Council Ref: DA205/15
(LD) (CIS)

12 August 2015

RE: SCECGS Redlands School Concept Proposal and Stage 1 Development

Figure 19: Proposed Access Location

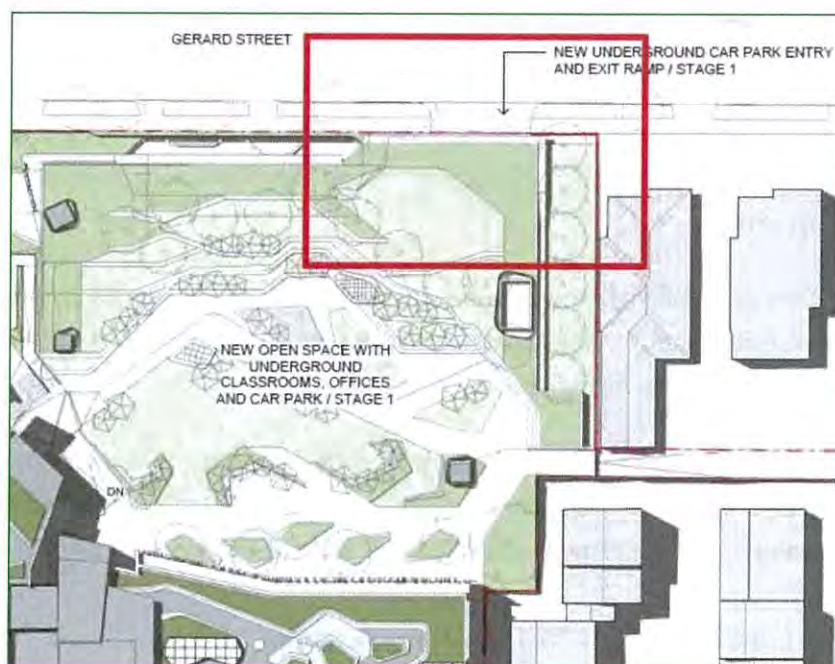
The vehicle access proposed on Gerard Street has been designed to accommodate future provision of 115 parking spaces and proposes separated entry and exit with a total width of 10 metres. A carpark with a capacity of less than 100 vehicles would require a combined driveway width of minimum 6 metres. Vehicular crossings in excess of 6 metres increase the length of the crossing for pedestrians which in turn increases the area of conflict between motorists and pedestrians.

If the vehicle crossing is approved, it is recommended that a median strip must be installed to restrict entry and exit to left-in; left-out to reduce turning conflicts and reduce conflicts with pedestrians.
